**From:** - [REDACTED]  
**Sent:** 27 July 2017 09:34  
**To:** Richard Temple  
**Cc:** yilmaz@yotu.co.uk  
**Subject:** RE: BR/199/17/PD 5-7 Station Road, Bognor Regis

Drawing
Proposed Drawings

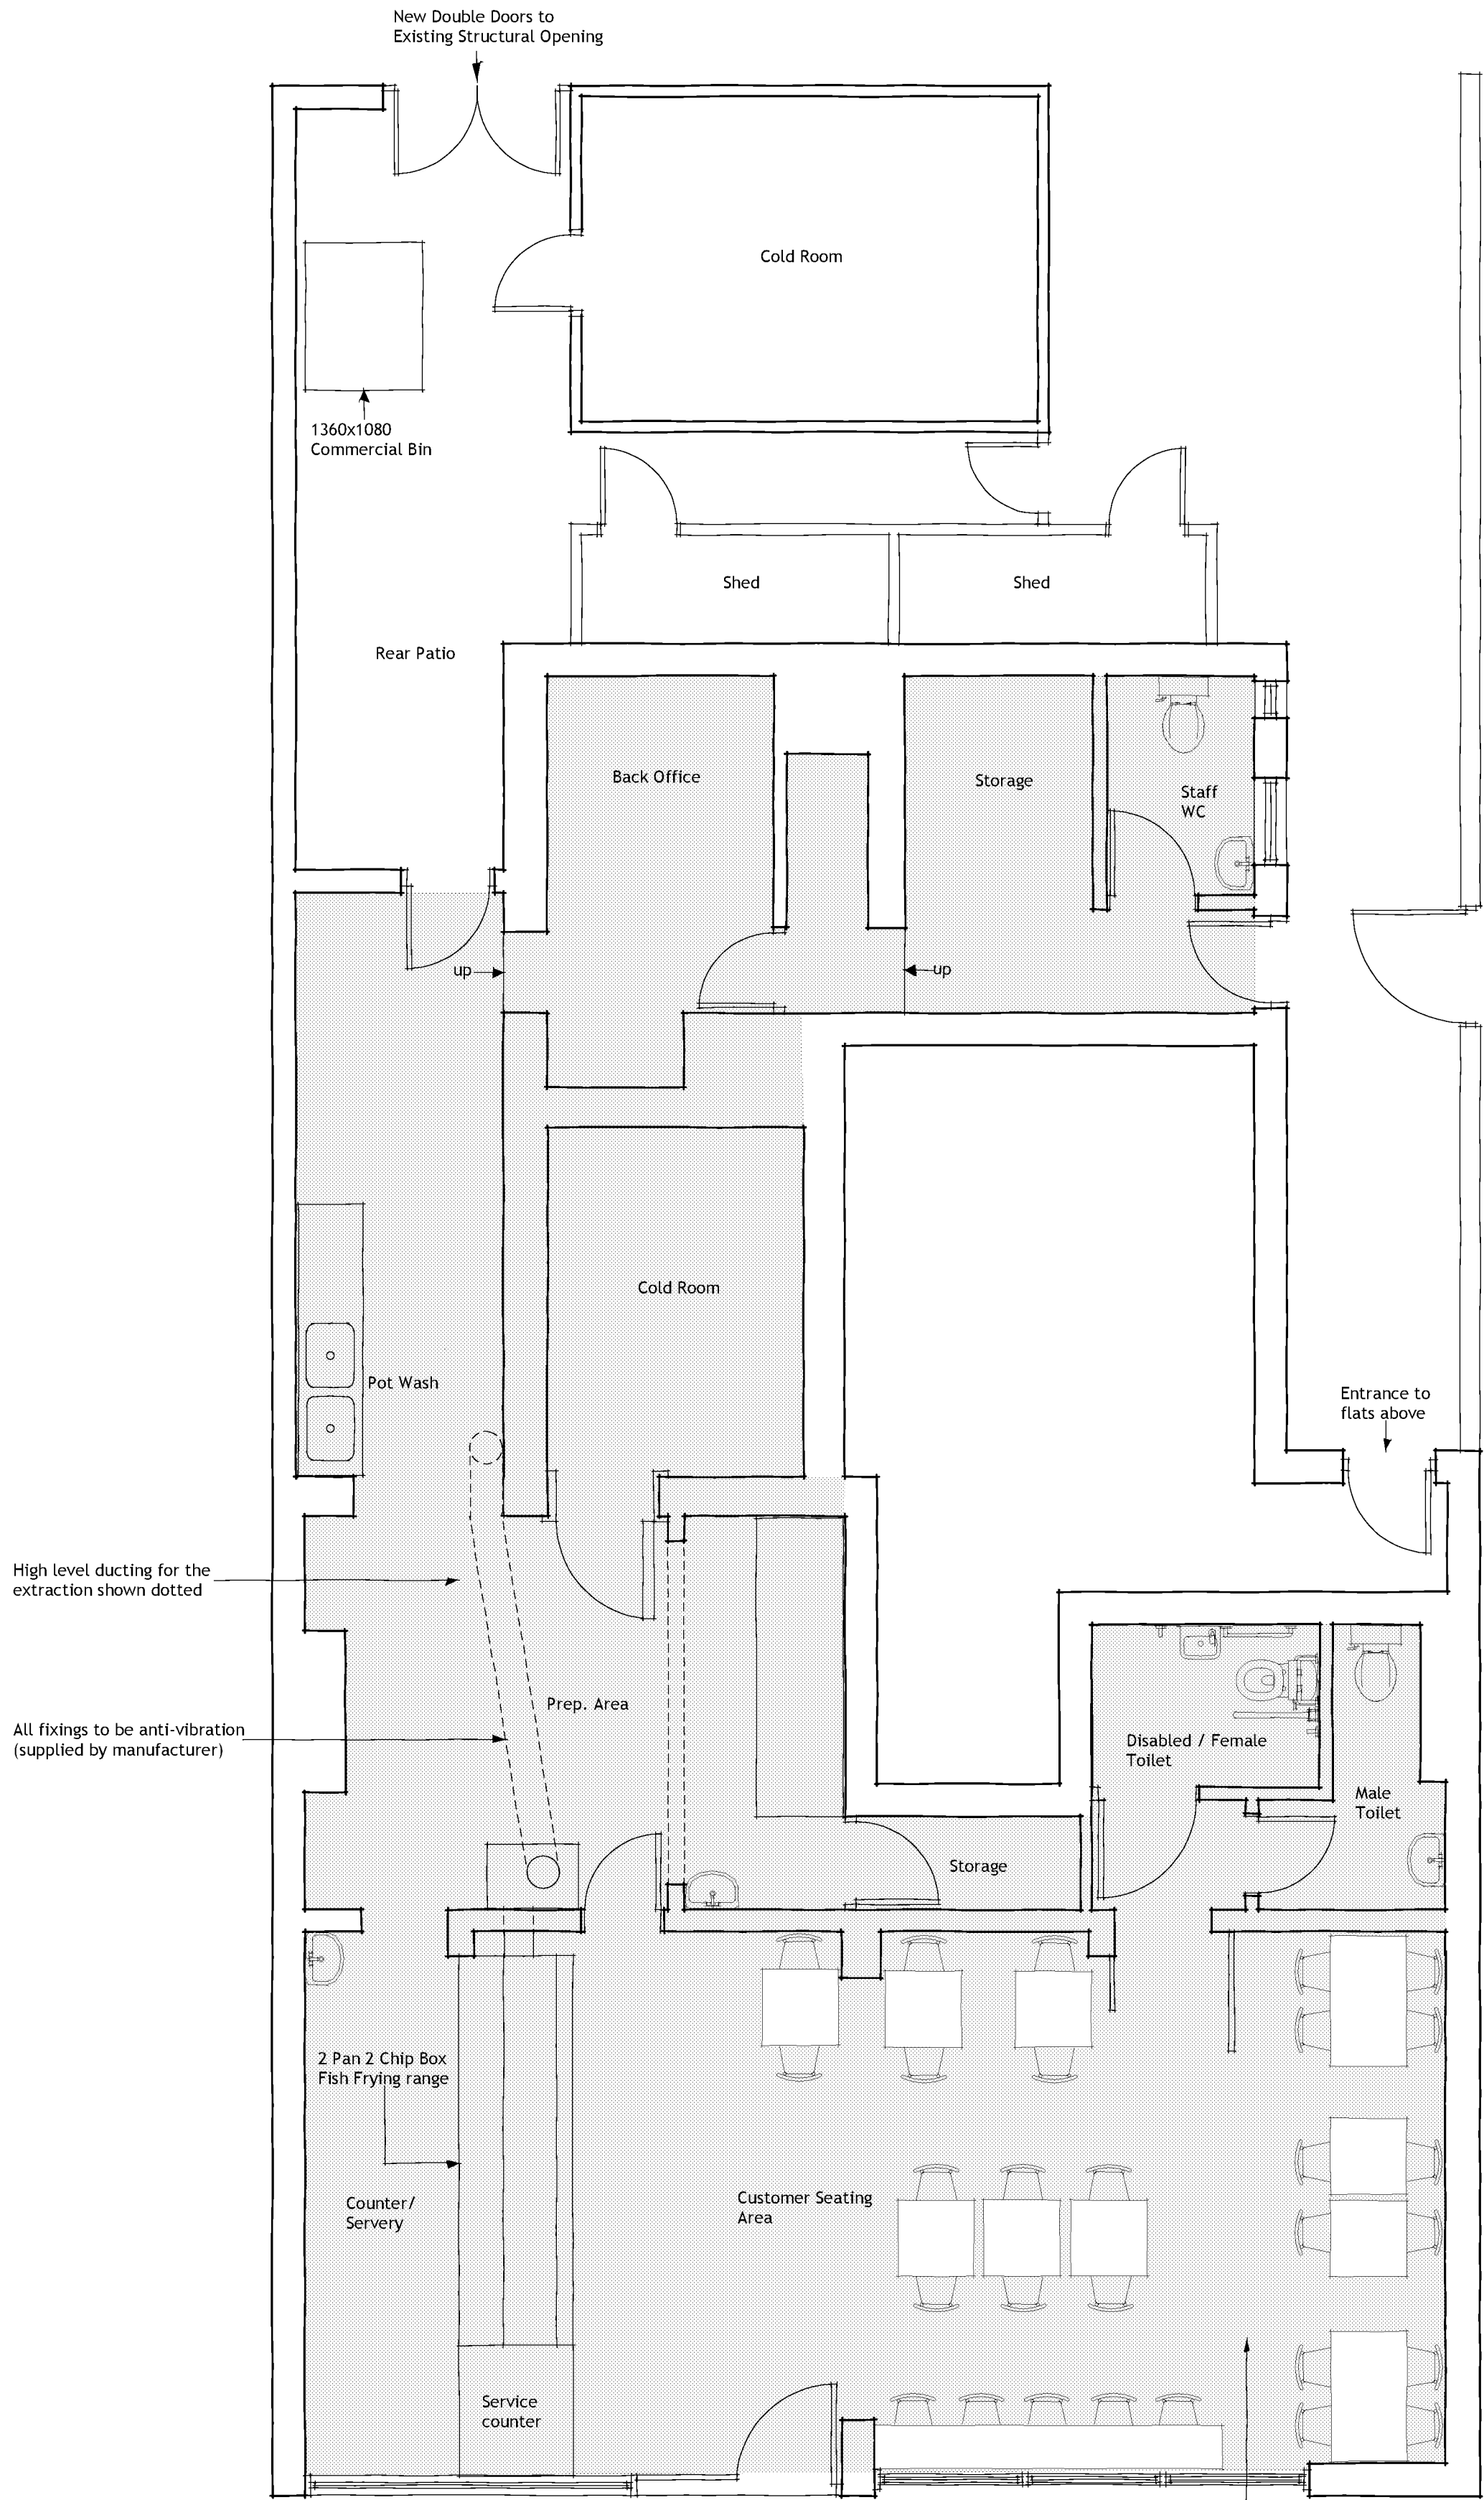
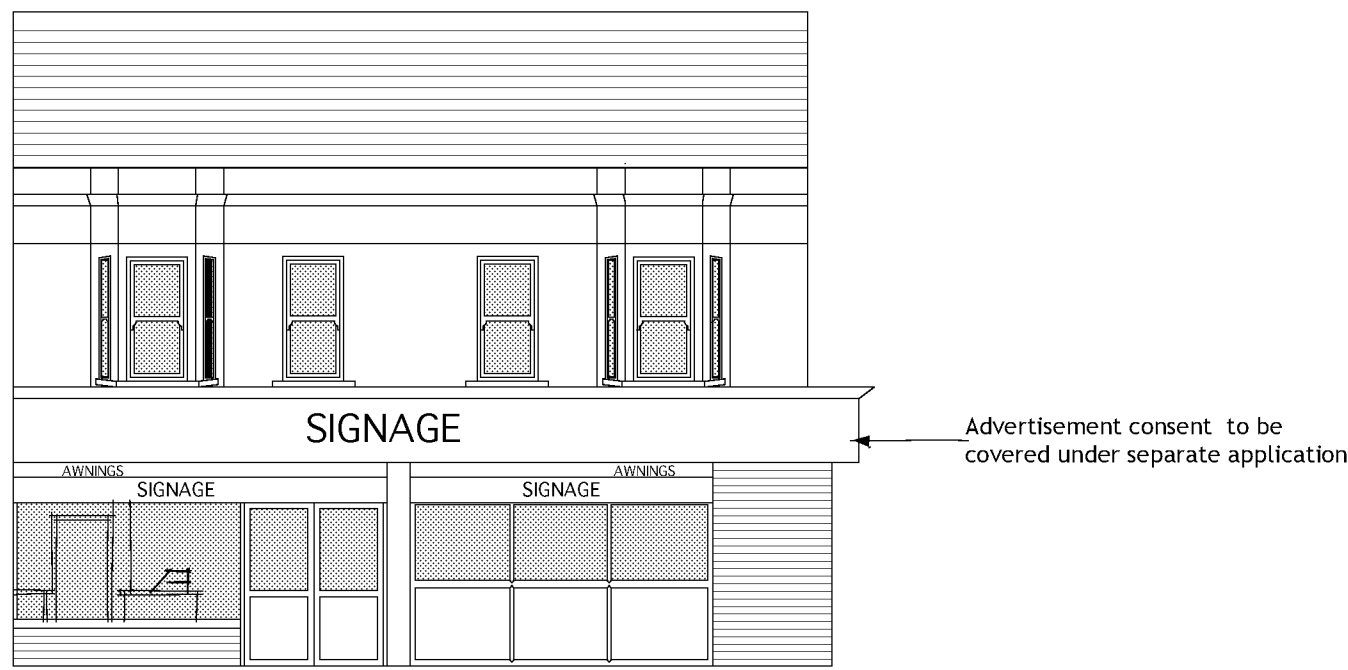
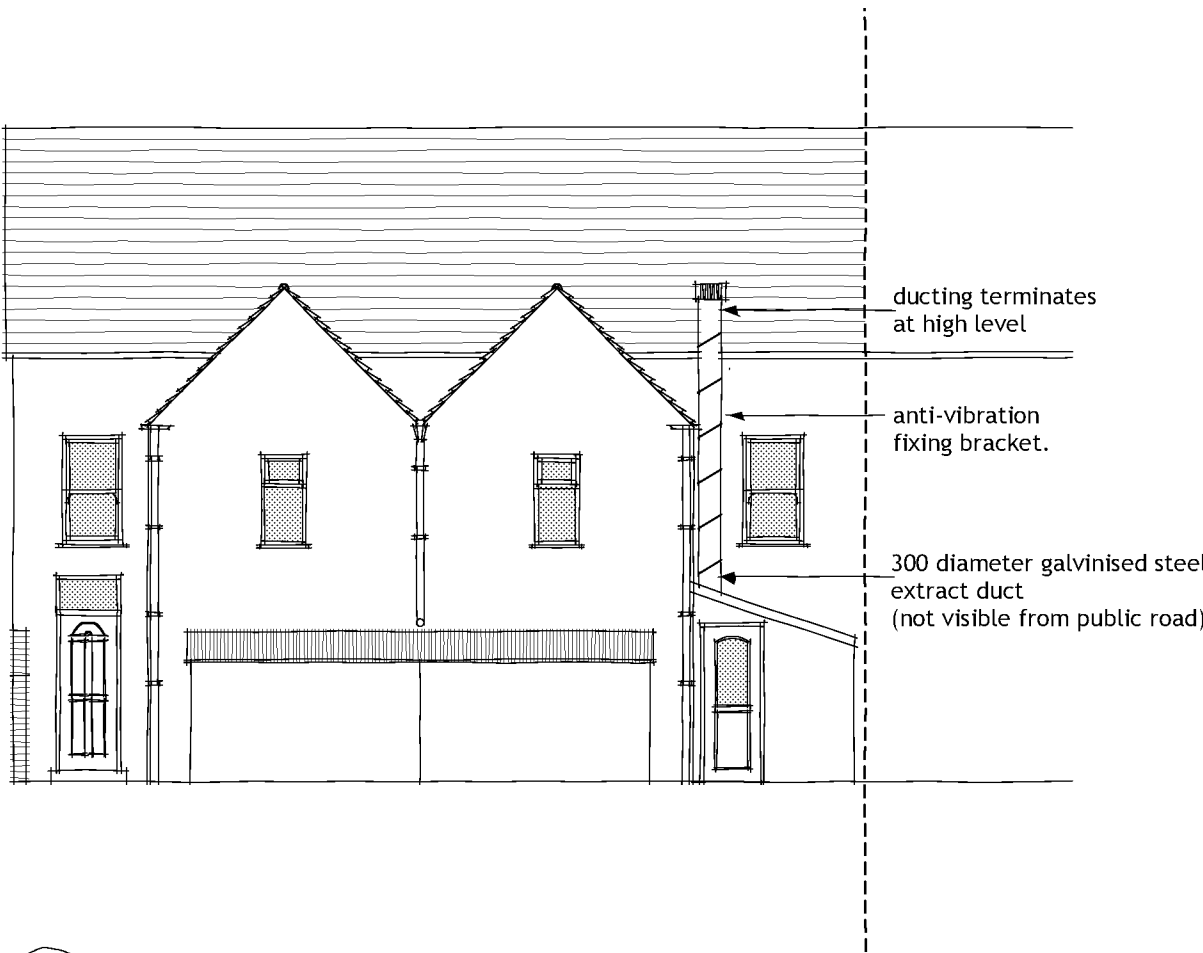
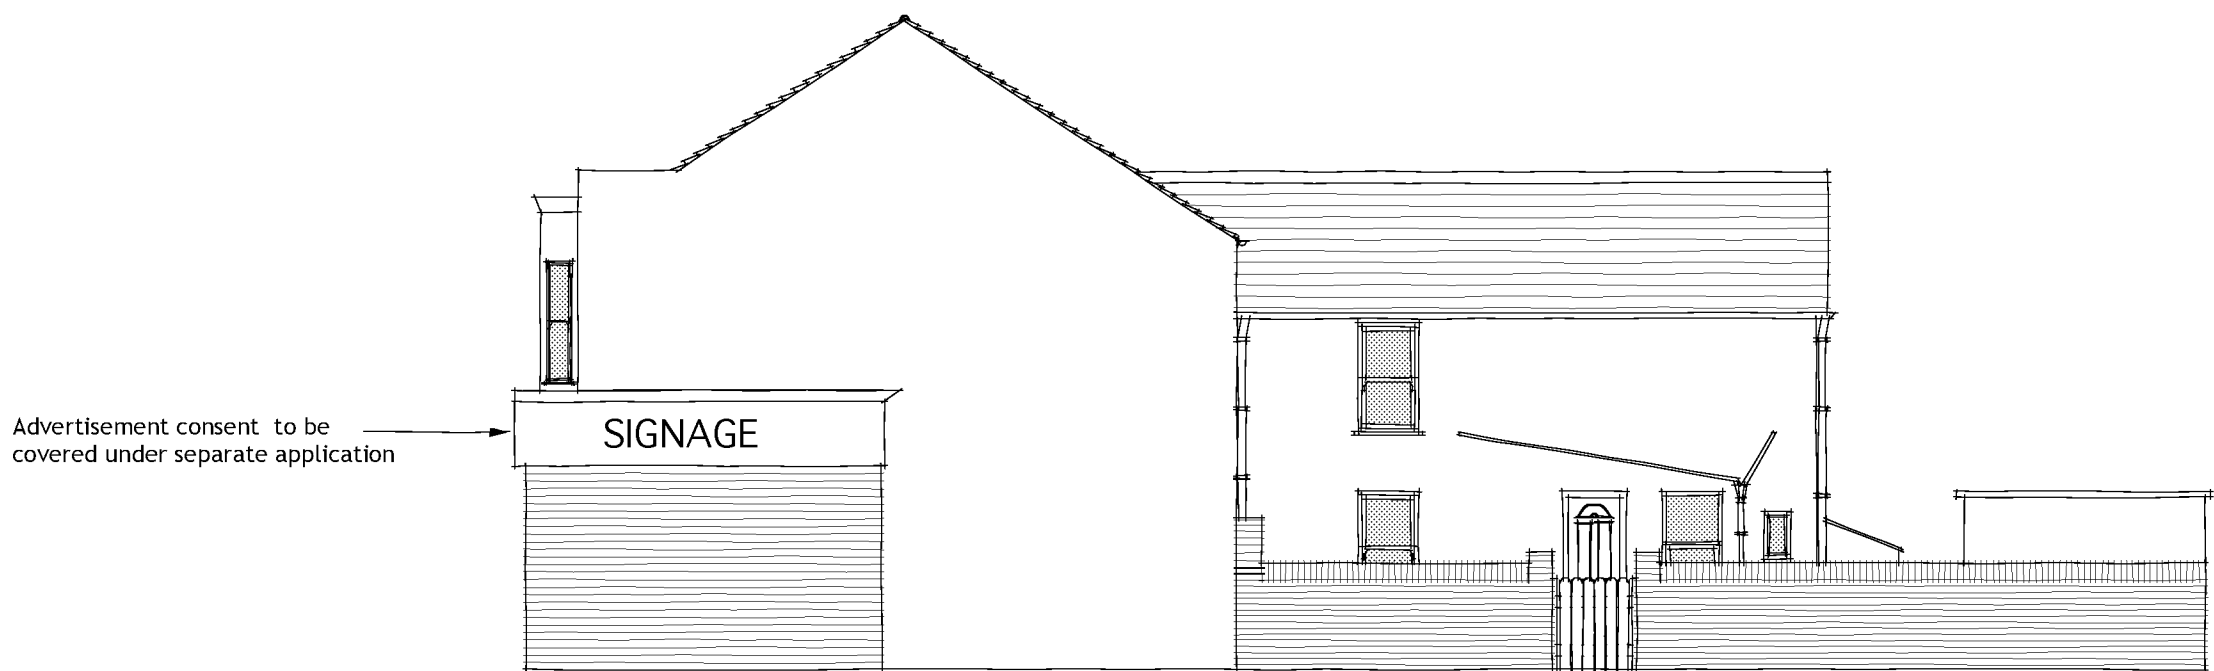
*"I have no objections to this in principle. However I note that it looks likely to be a premises serving Fish and Chips and that the applicant has shown on the plans where the ducting for the kitchen ventilation will be. As there are residential premises above, there is the potential for both noise and odour to affect the residents of the flats. Please could the applicant submit further details to allow assessment of the proposed extraction unit to be carried out. I would direct the applicant to the DEFRA guidance 'Guidance on the Control of Odour and Noise from Commercial Kitchen Extract Systems, January 2005).*

*Should this information not be forthcoming, Environmental Health would be likely to object on the grounds of insufficient information on noise."*

Please find attached proposed specification sheet for the extraction system provided by Sussex Catering Equipment Ltd.

We are in contact with the supplier of the extraction system, who have agreed to provide the proposed technical details of the noise and odour control measures for your approval. We will forward this information as soon as it becomes available, hopefully by the end of this week.
